COUNTY COUNCIL'S RESPONSE TO CONSULTATION ON THE FOLLOWING DEVELOPMENT PROPOSAL

Application No: 18/00584/REM

Proposal: Reserved matters application to 15/01012/OUT - Development of up to 48,308sqm of employment floorspace (Class B1c, B2, B8 and ancillary B1a uses), the siting of buildings to the south of the site, servicing and circulation areas, vehicular and pedestrian access from Skimmingdish Lane and landscaping

Location: Land North East Of Skimmingdish Lane Launton

Orig Title
CYCLE SHELTER DETAILS

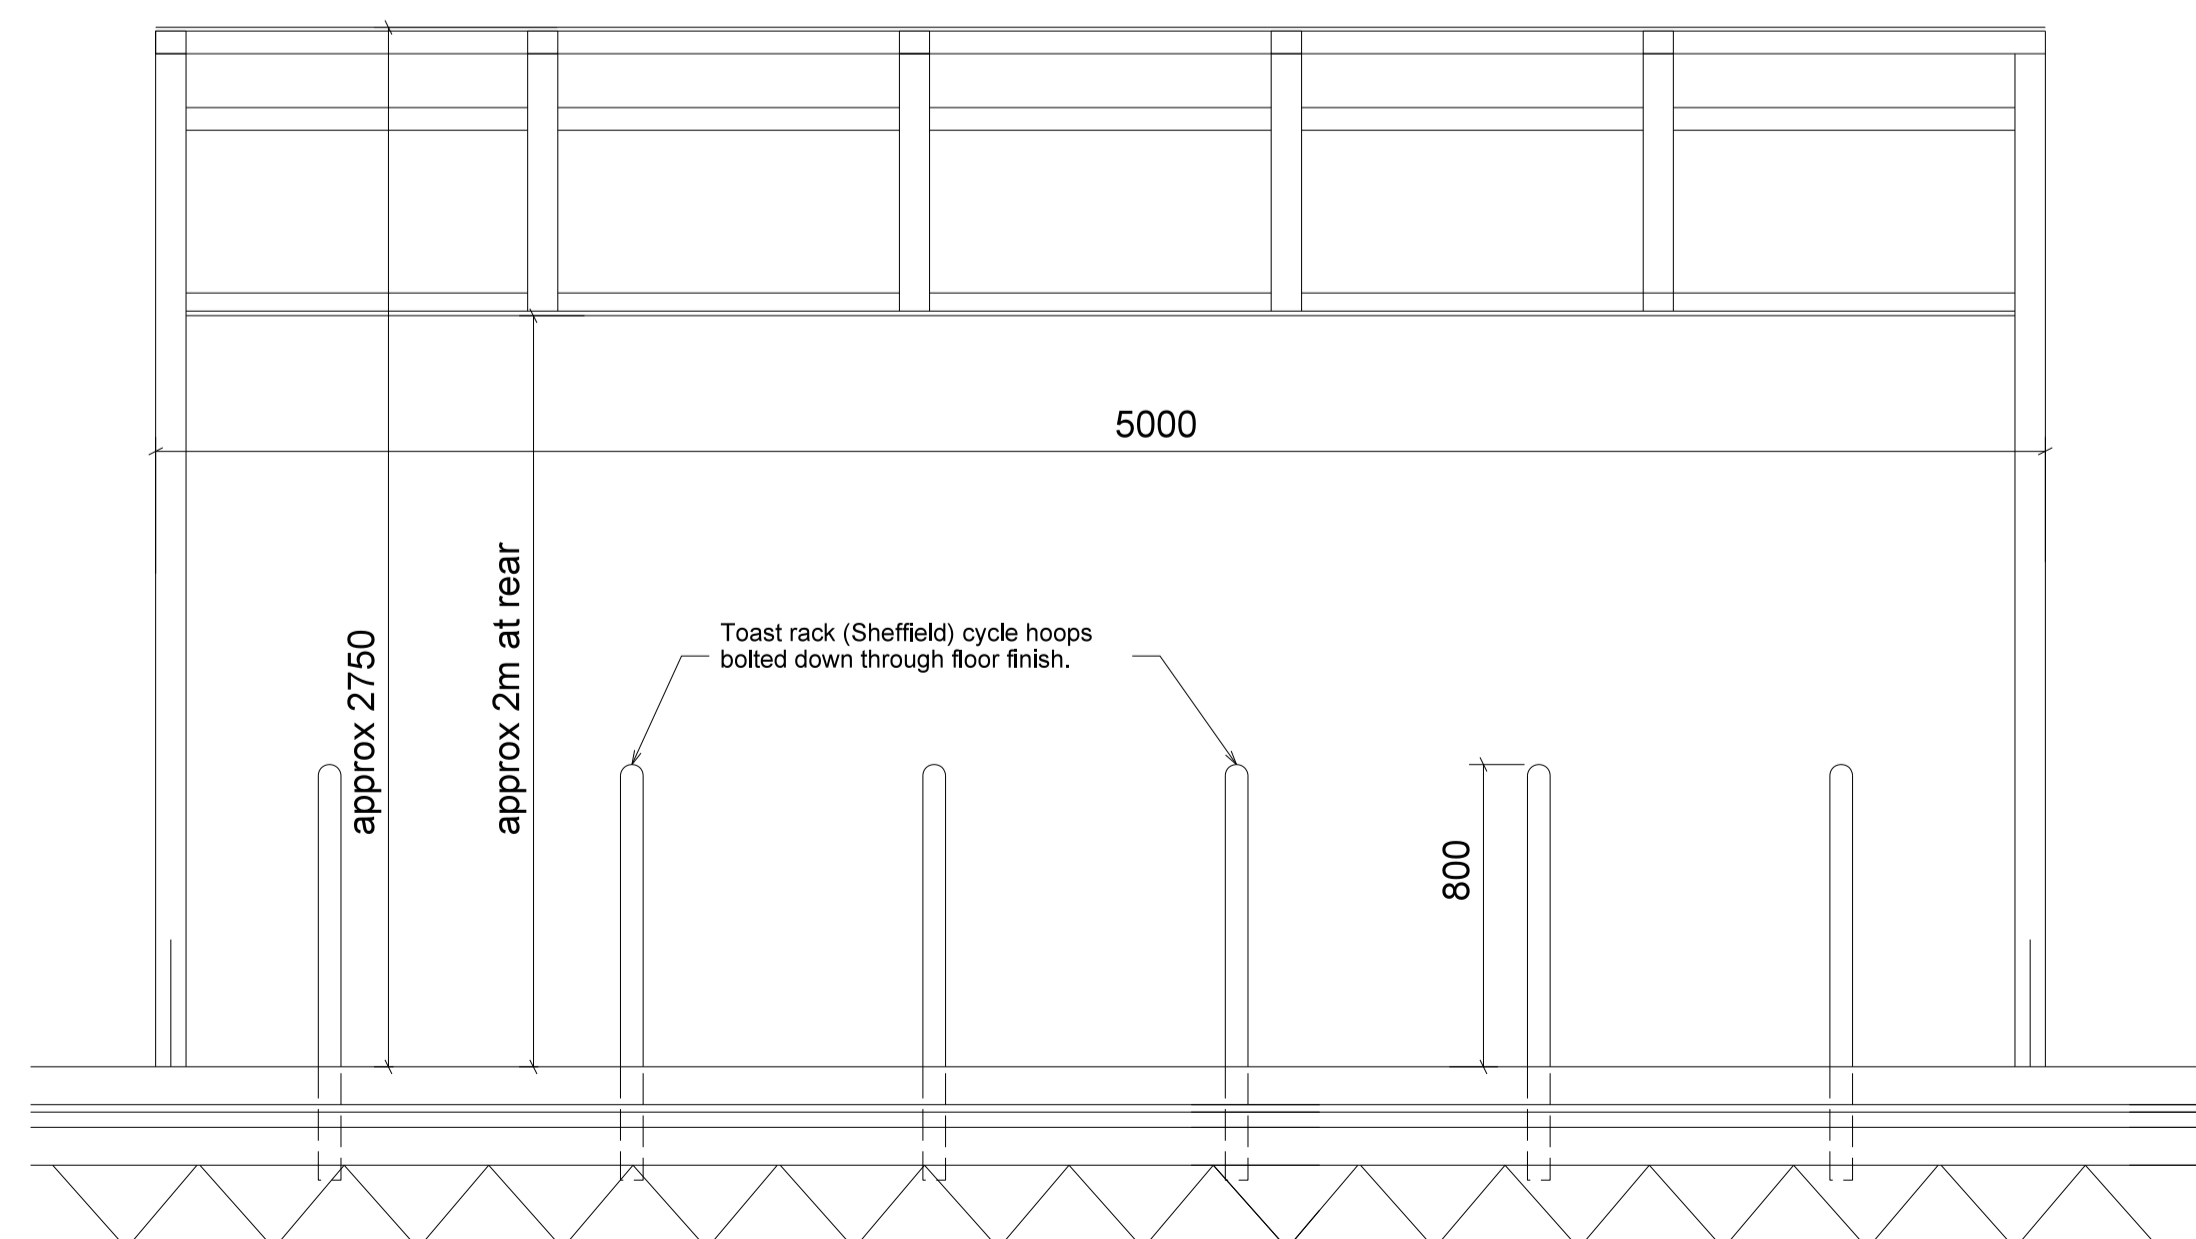
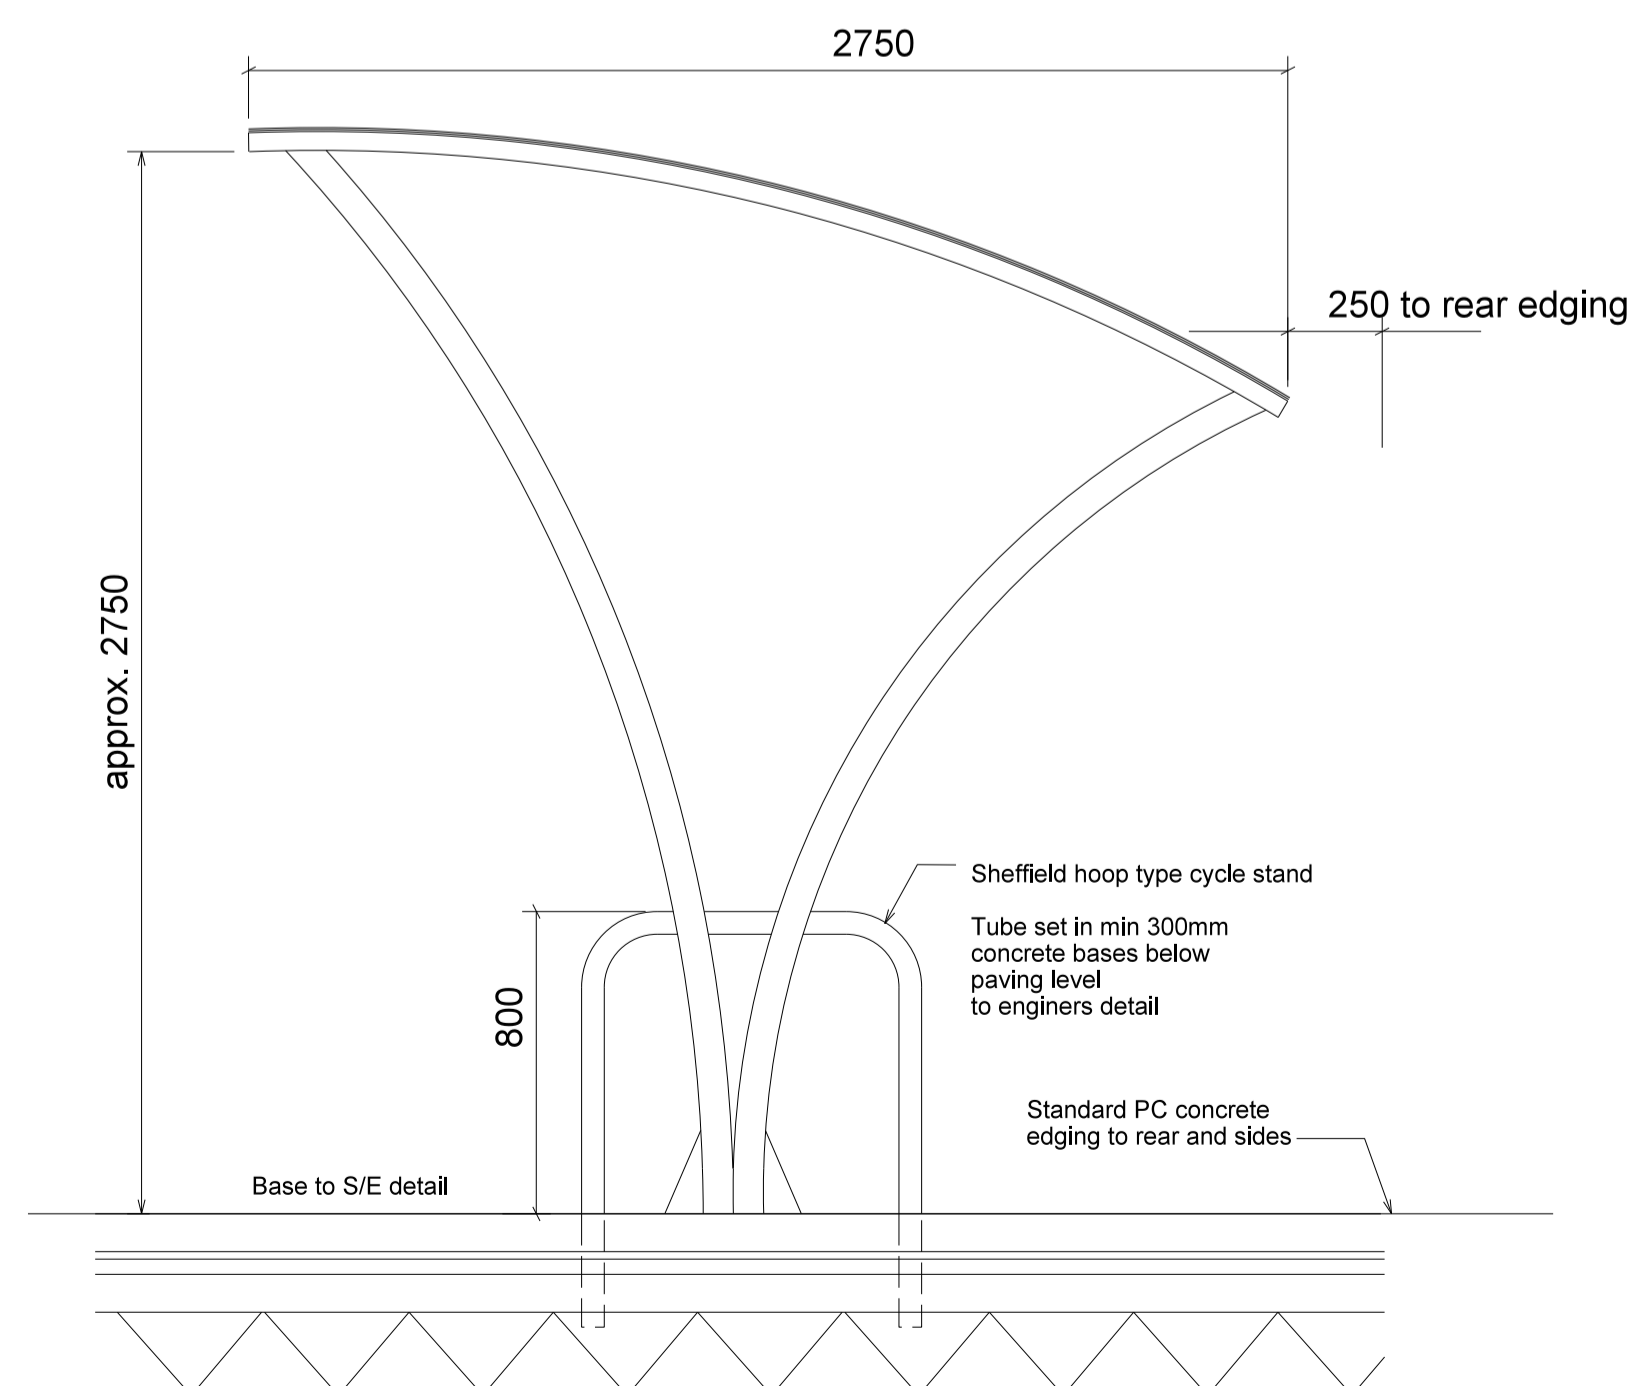
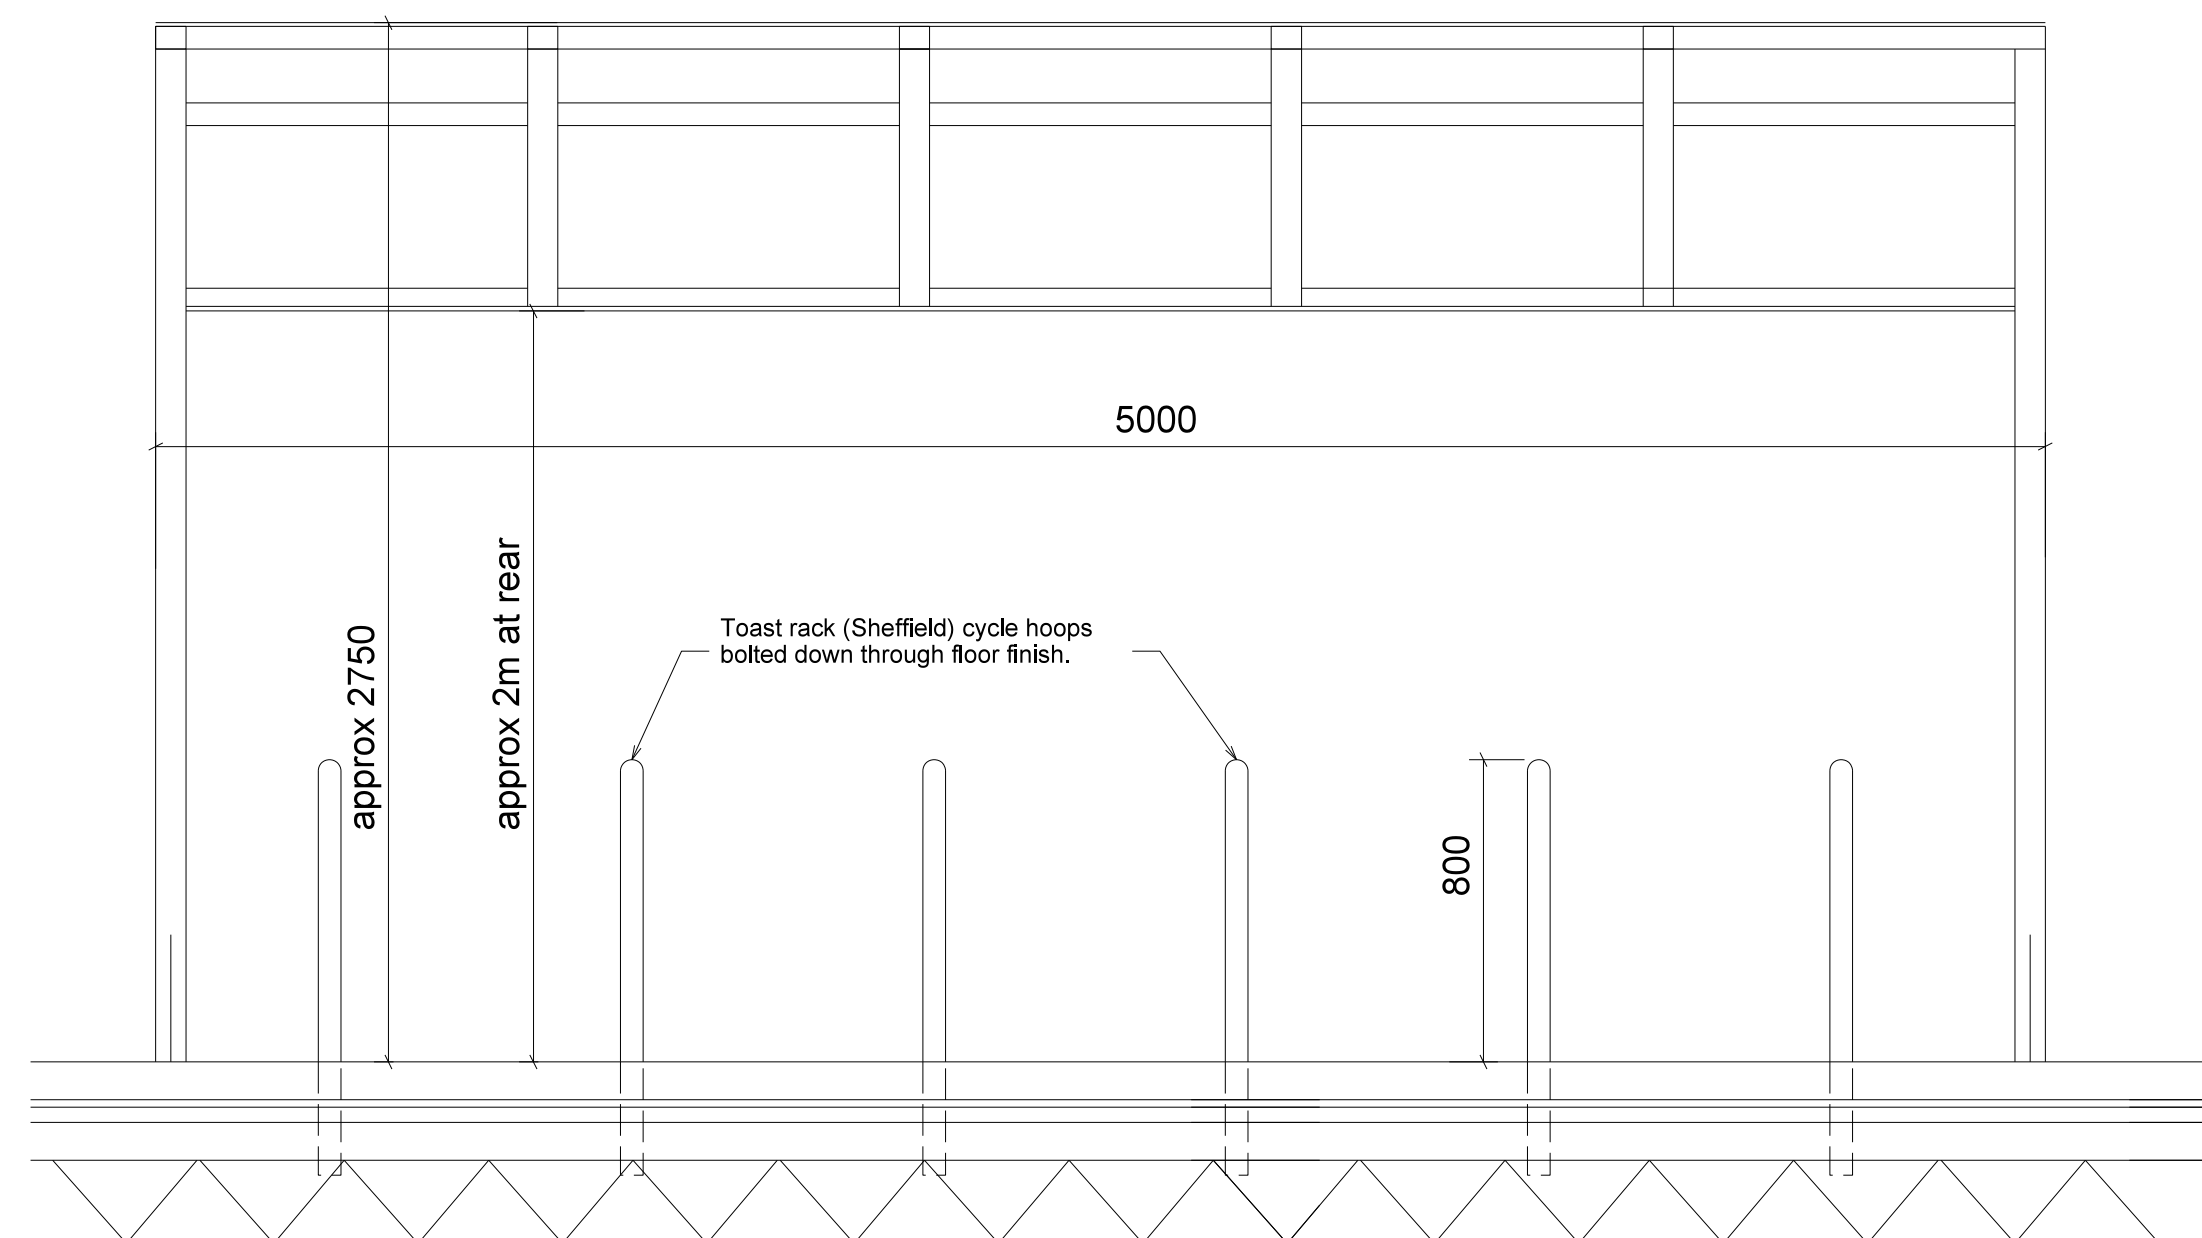
Notwithstanding the details shown on drawing number 17007 / TP / 1018 (Cycle Shelter Details) and prior to the first occupation of the development hereby approved, full details of the covered cycle parking facilities to be provided on the site shall be submitted to and approved in writing by the Local Planning Authority. Thereafter, the covered cycle parking facilities shall be provided, permanently retained and maintained for the parking of cycles in connection with the development in accordance with the approved details.

There is some inconsistency in the information relating to cycle parking provision. The Proposed Site Plan (Drg. No. 17007 / TP / 1003) and other drawings label 24no. cycles for each unit, as stated in 3.15 of the Reserved Matters Report. However, the Parking Note in Appendix 2 of the same Report states that there will be 24 **hoops** per unit, i.e. storage for 48 cycles per unit.

Considering the relative floor areas of the plots, it is concluded that the minimum storage must be at least that as defined in the Parking Note, i.e. 24 stands (48 spaces) for each Unit 1A and 1B.
